File No: R/2014/39/A
Our Ref: 2015/059562

RE: SSD 6751 – Sandstone Precinct Stage 1 State Significant Development

This submission comprises the City of Sydney's (the City's) comments on the approvals process, subterranean development and extended building envelope associated with the SSDA.

FIGURE 10 – INDICATIVE PROPOSED BUILDING ENVELOPE (LOOKING SOUTH)

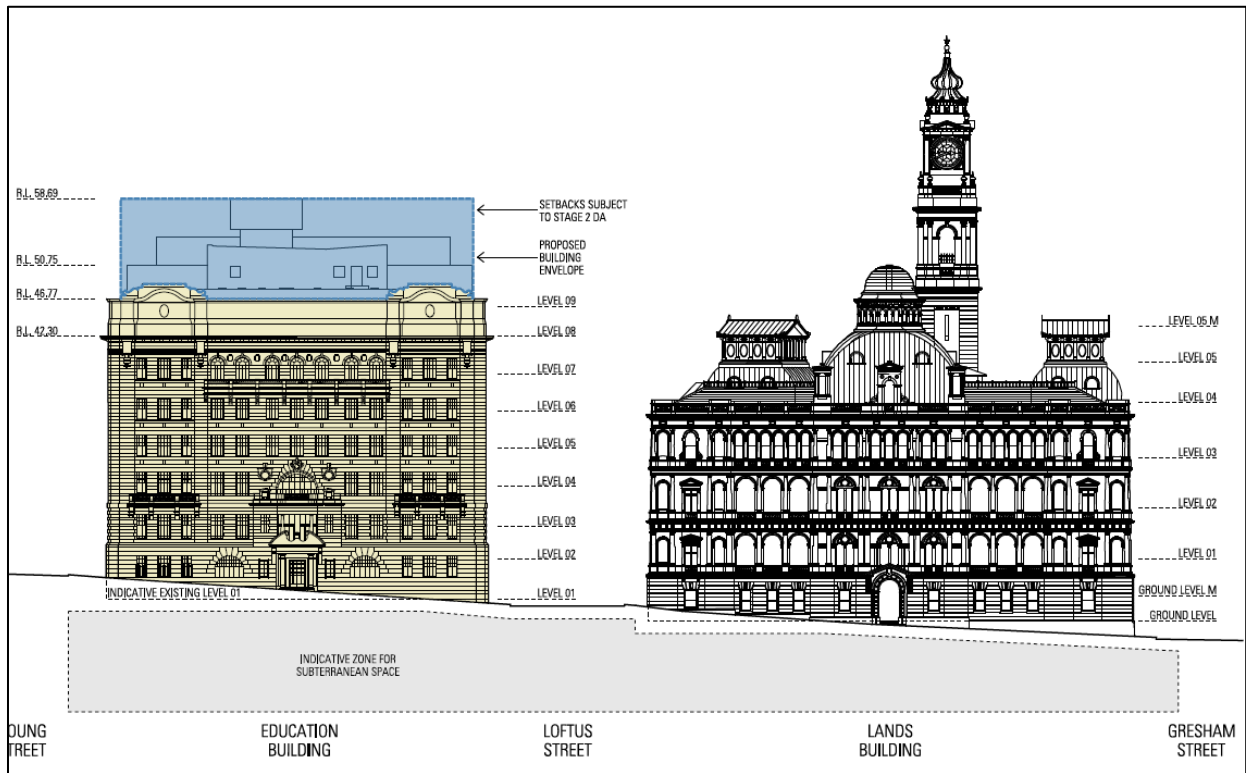
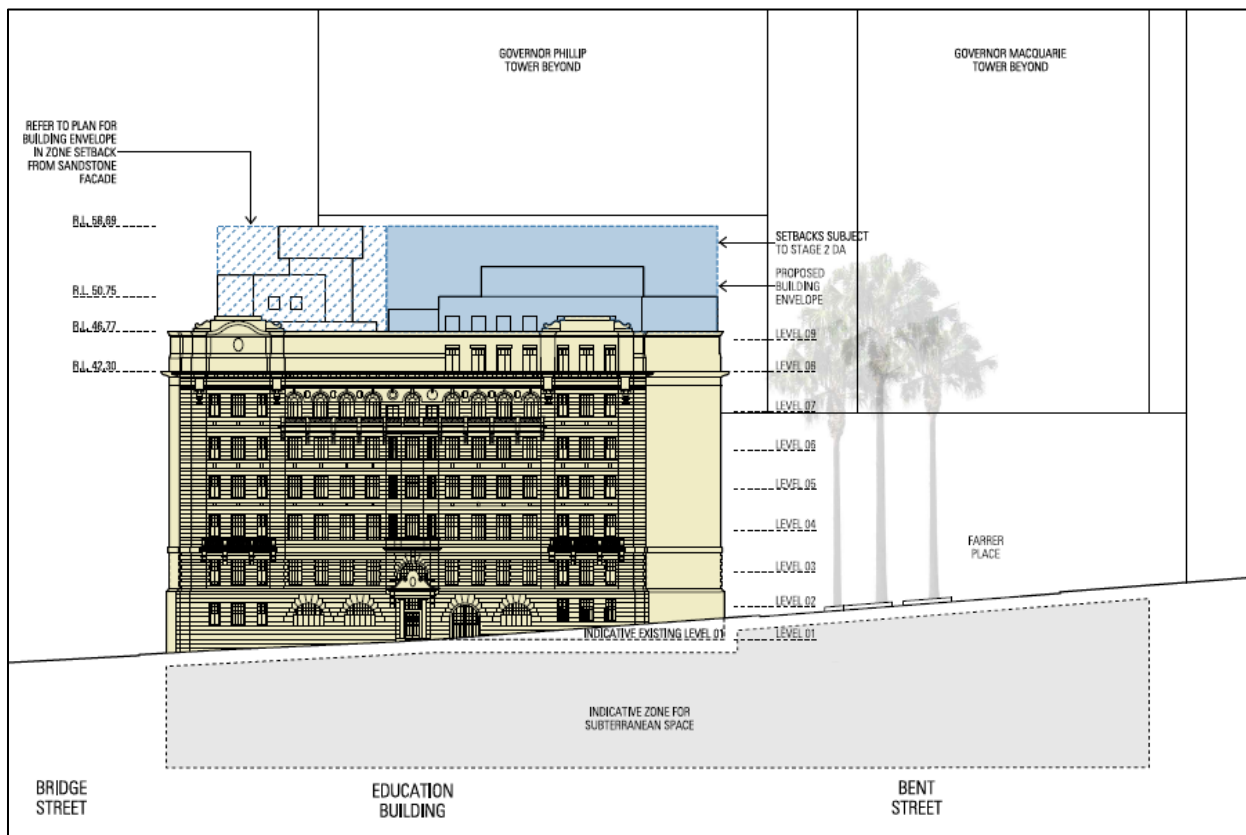
The proposed building envelope of the additions to the Education Building is too loose at this stage and should have greater definition. The building envelope is too large at the south, east and west and should be setback from the existing building footprint a further 2m to appear less prominent.

Although the DA has been lodged on the basis of the envelope being defined at Stage 2 phase, the City requests that the building envelope be better defined at this stage to provide greater certainty for the Stage 2 DA.
